East Anglia ONE North and East Anglia TWO Offshore Windfarms

Applicants' Comments on Suffolk Energy Action Solutions' Deadline 6 Submissions

Document Reference: ExA.AS-27.D8.V1

Date: 25th March 2021

| | Rev | Date | By | Comment | Approved: | AH | | | APFP Ref: 5(2) (o) | | Doc ref: 2.10 |

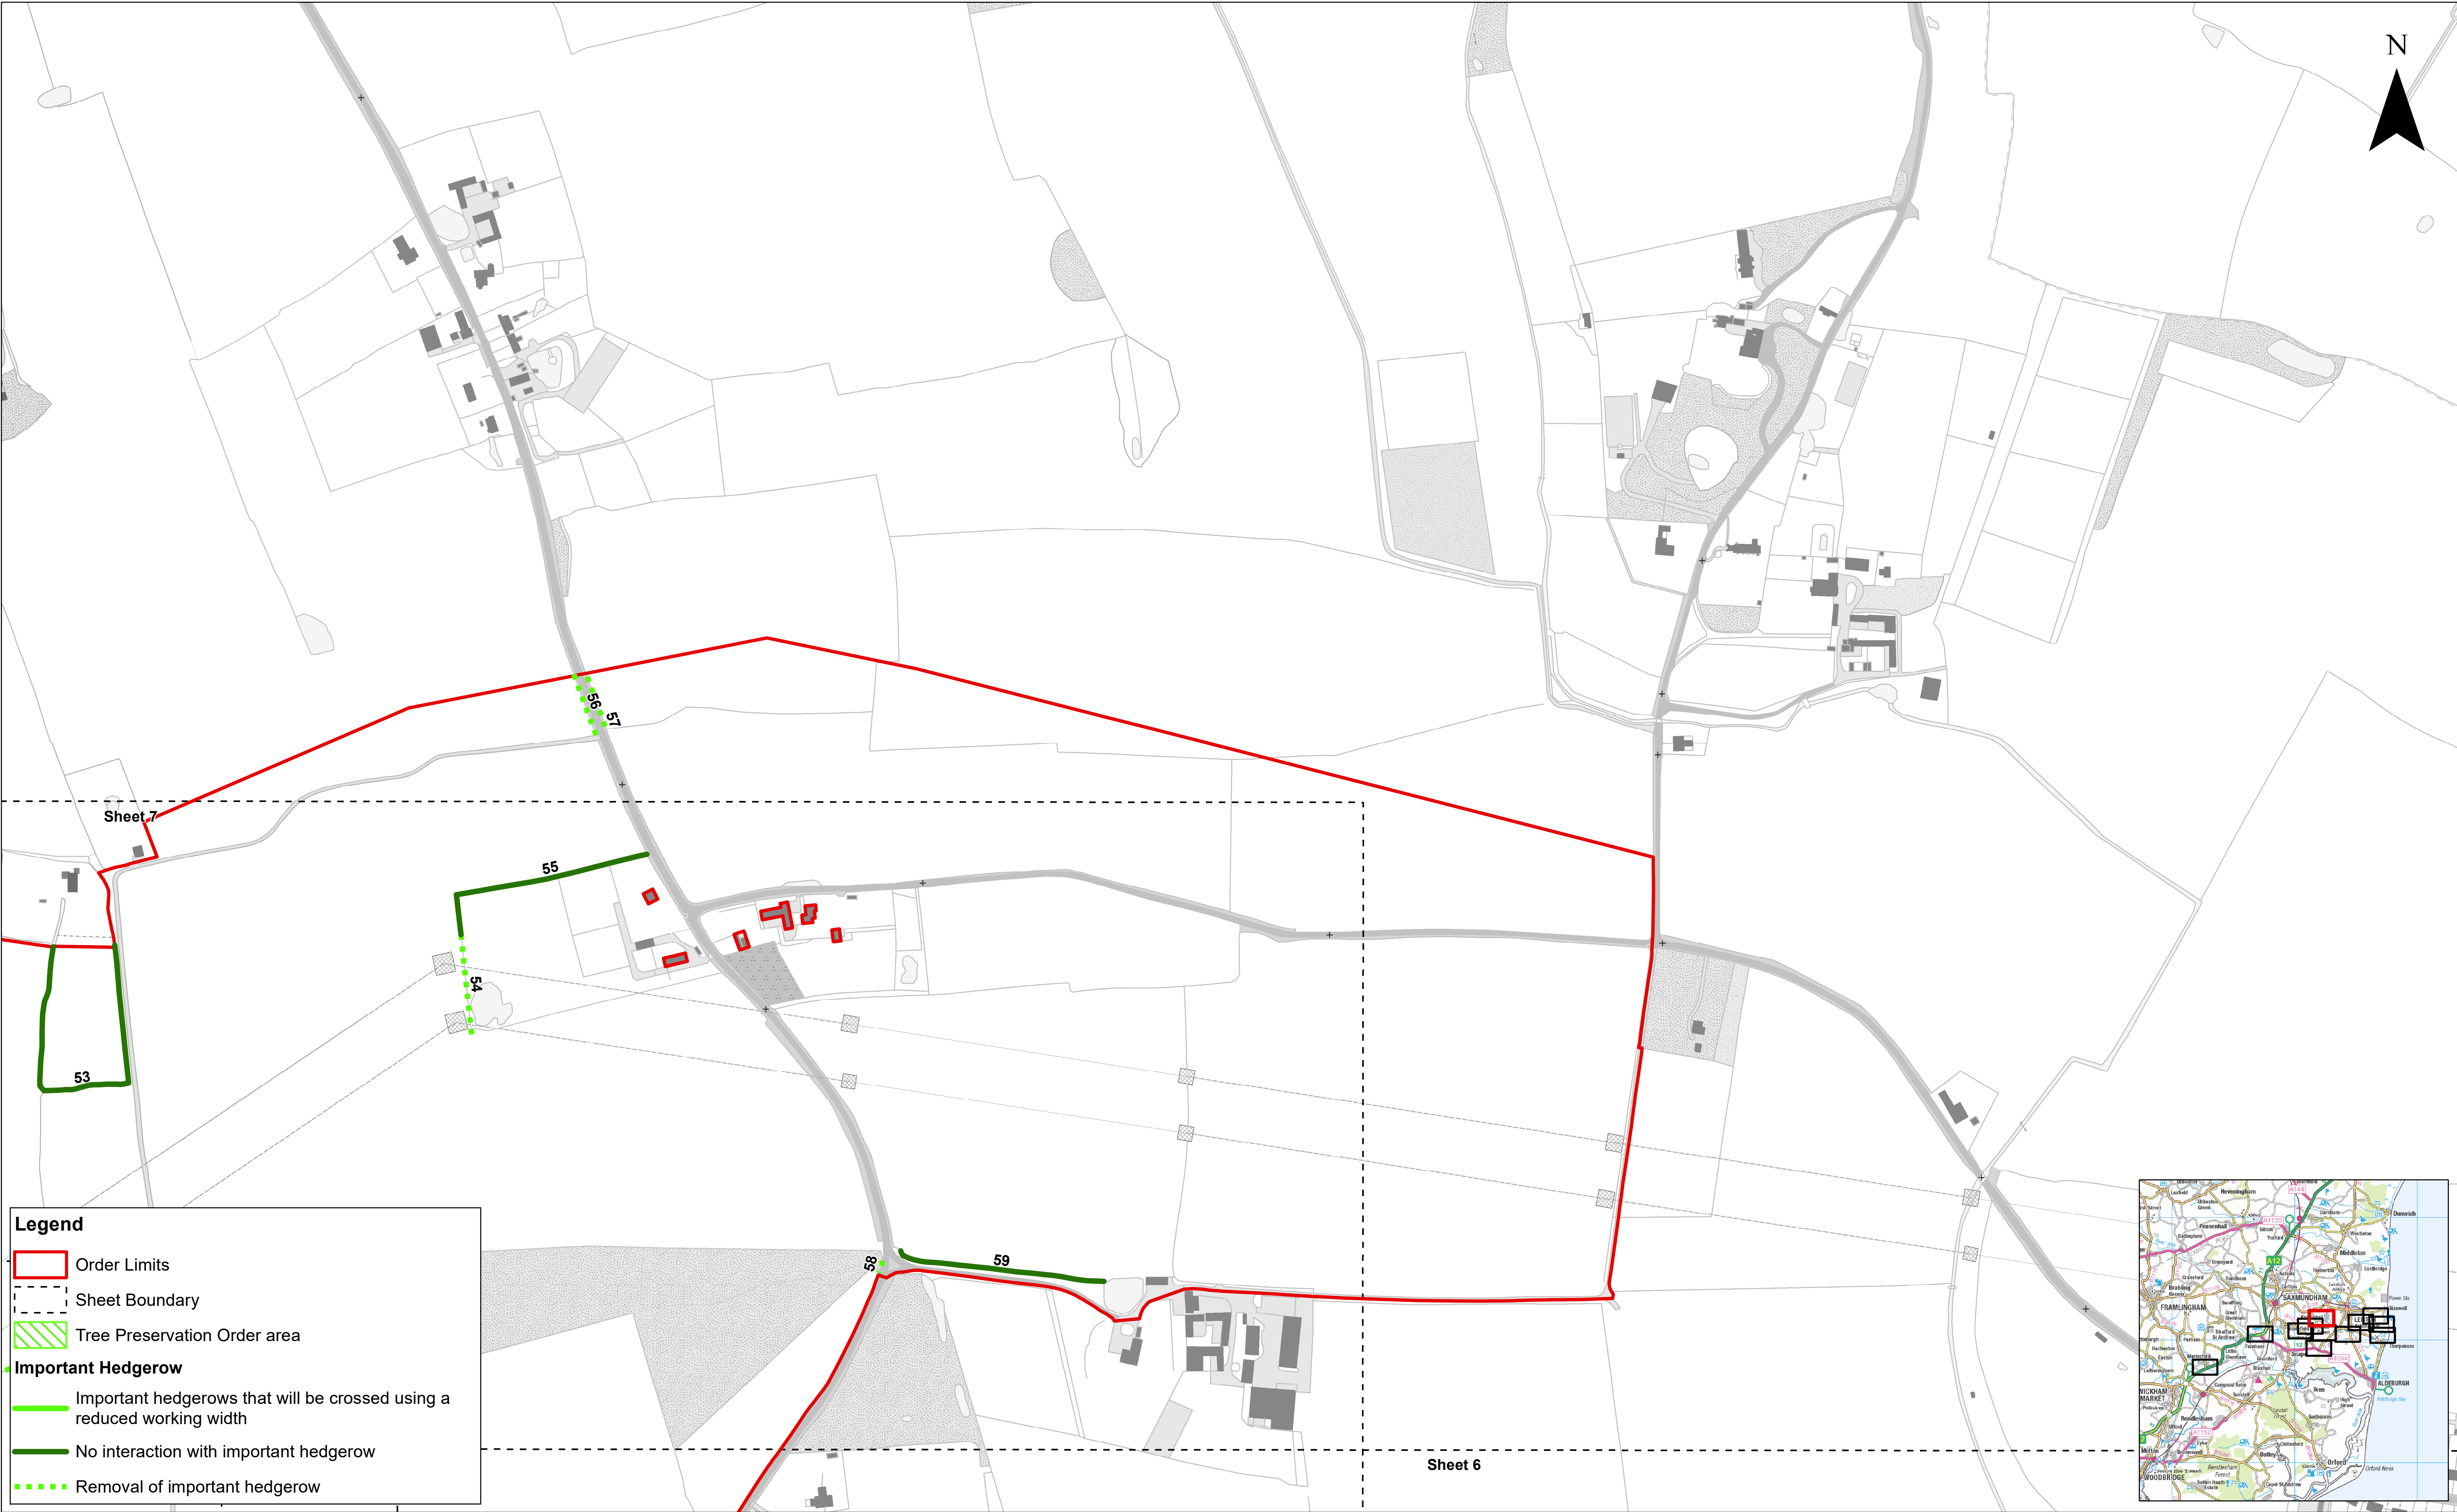
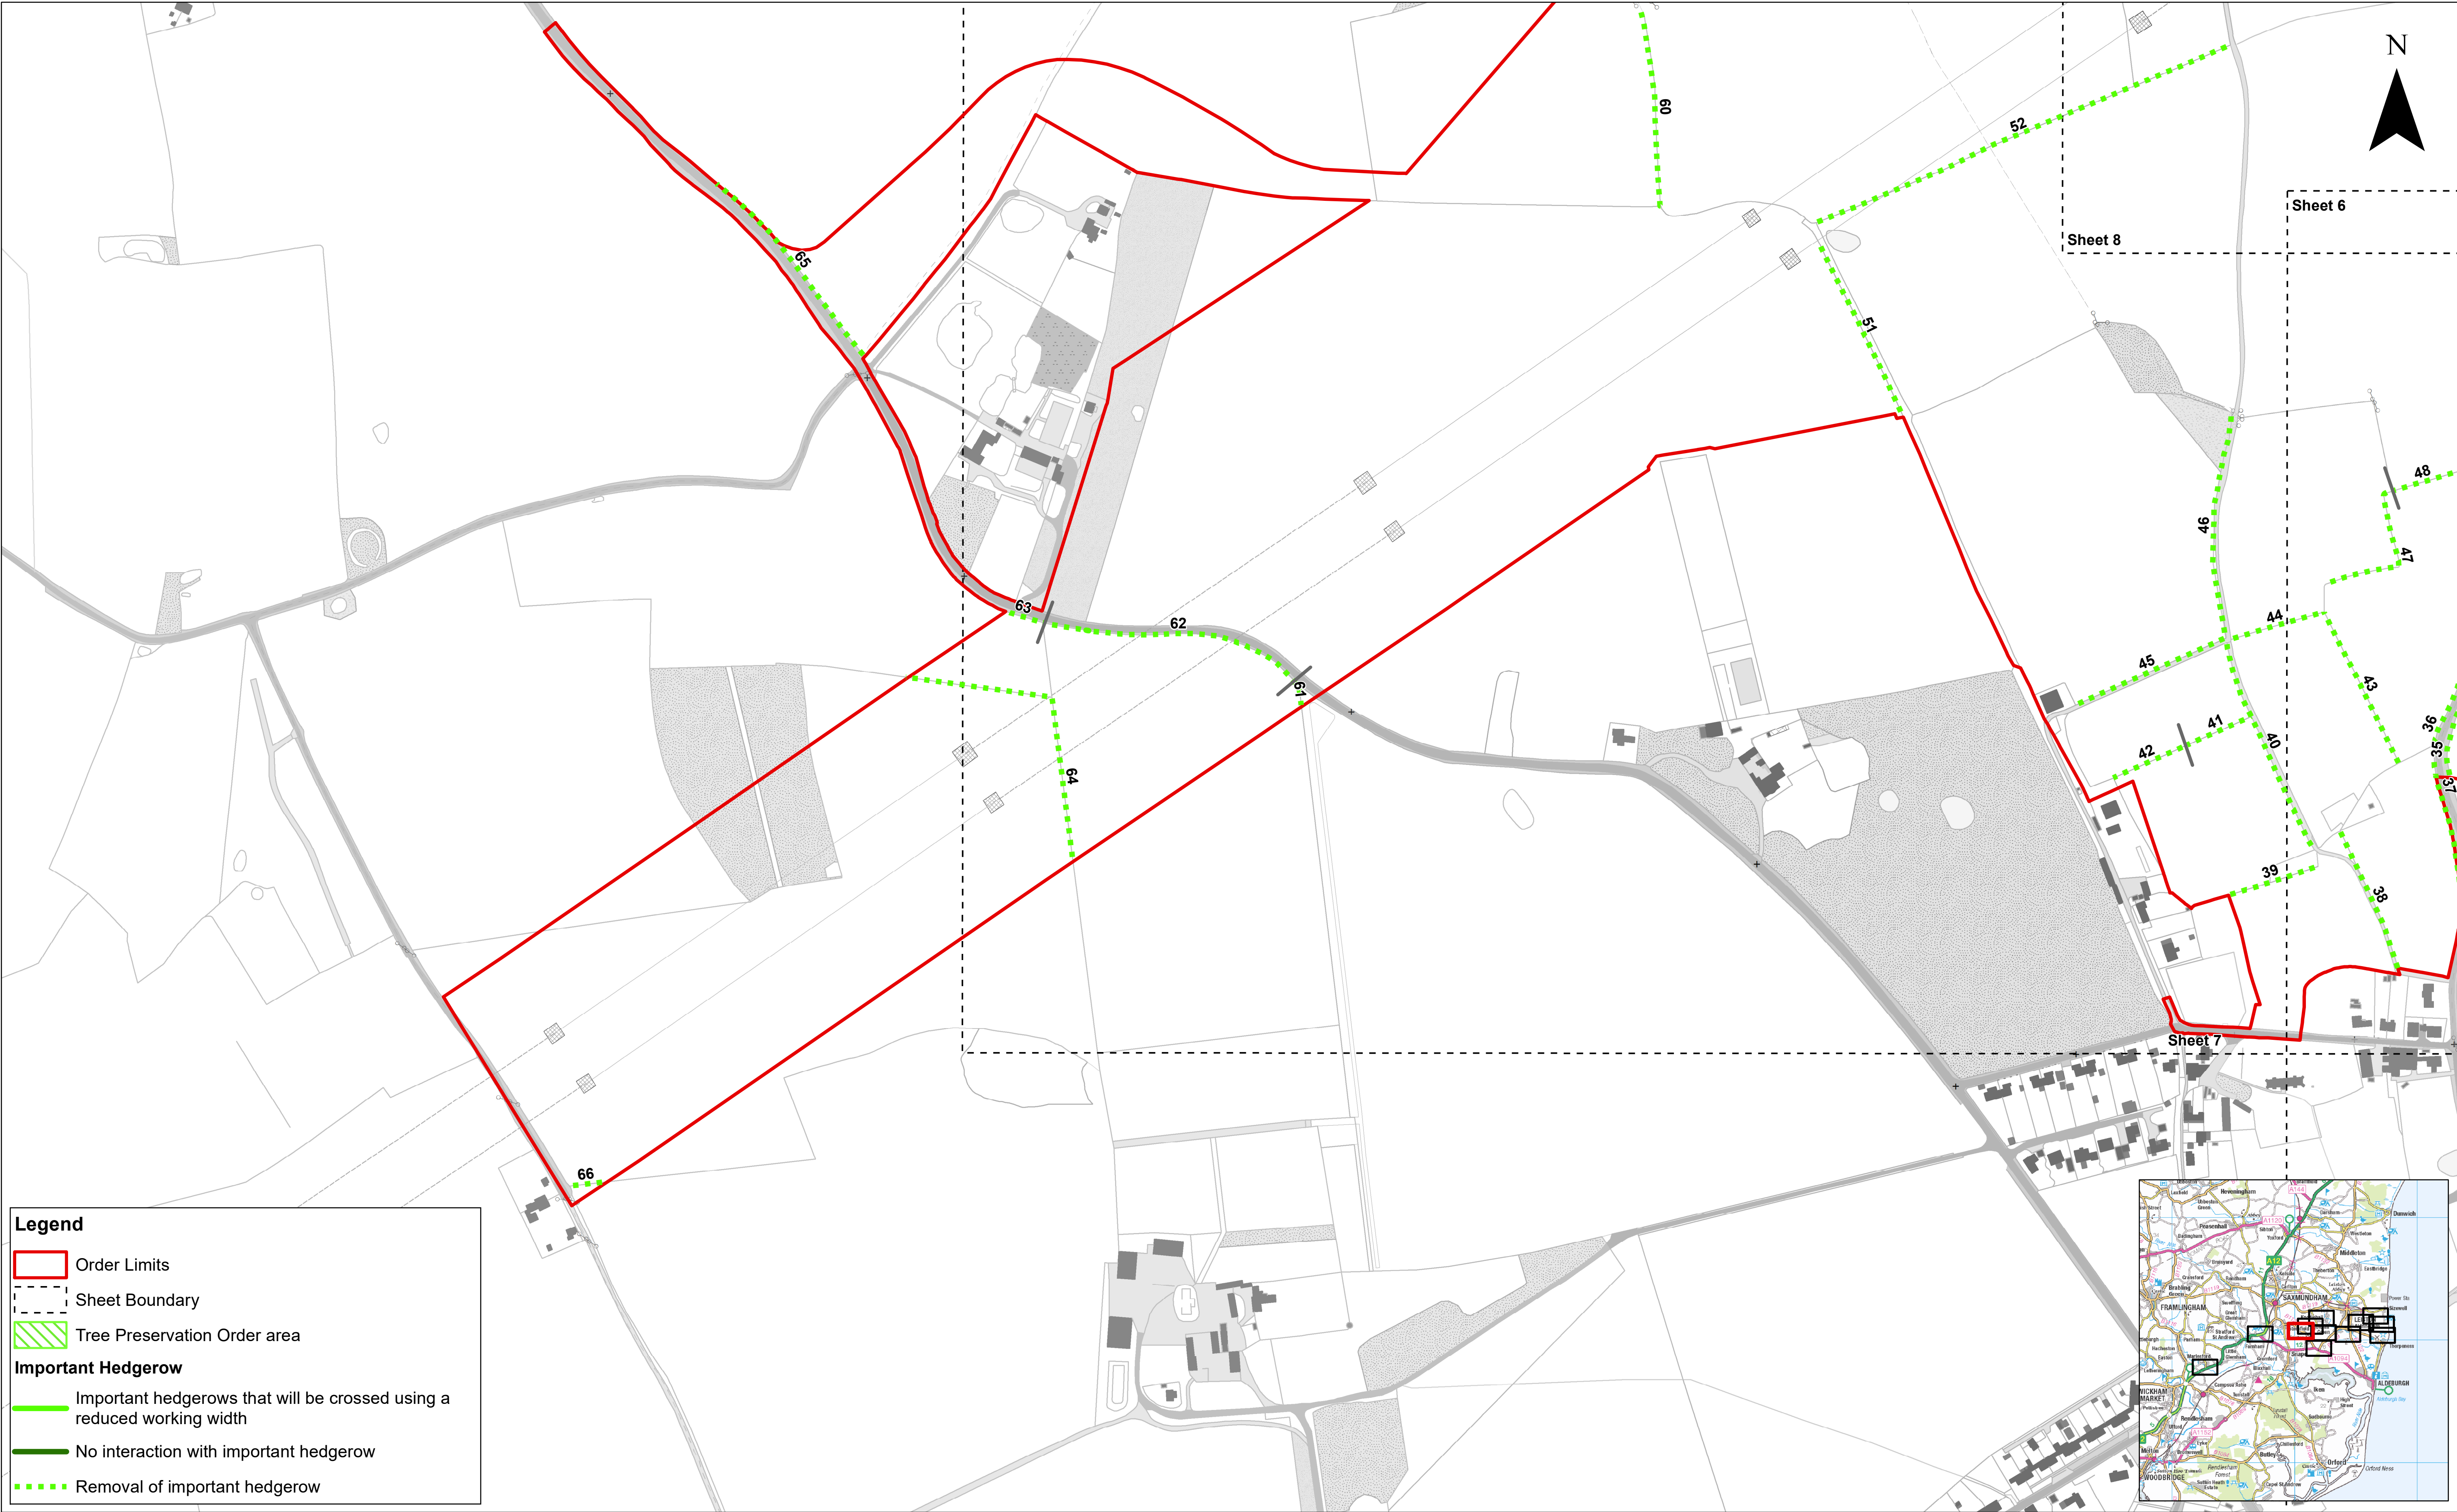
ID	SEAS' Comments	Applicants' Comments
45	6.10 Both hedges will have to be removed.	The Applicants note that the length of hedgerow associated with Fitches Lane required for removal in this area is important hedgerow marked 21 on sheet 5 of 12 of the Important Hedgerows and Tree Preservation Order Plan (REP3-010).
46	6.11 Fitches Lane and the paths through the wood are resources joining two villages, enabling children to walk to the Primary School, as well as offering places for children to play. Although there has been some development by the new owners in recent years (one owner's child has a bike track in an area of the wood), we still hear our migrant birds return each spring. The construction will remove this resource and the Lane.	Noted. The Applicants note that a temporary diversion of the public right of way (PRoW) E-260/007/0 (from the western end of Fitches Lane towards Coldfair Green) will be required during construction. This temporary diversion will be implemented in accordance with the final Public Rights of Way Strategy, which must accord with the Outline Public Rights of Way Strategy (REP3-024) and be approved by the relevant planning authority prior to undertaking works that would affect the PRoW, pursuant to Requirement 32 of the draft DCO (document reference 3.1). Pursuant to Article 11 of the draft DCO , temporary PRoW diversions must be provided to the standard defined in the Outline Public Rights of Way Strategy (REP3-024), to the satisfaction of the relevant highway authority, prior to the stopping up of the existing PRoW.
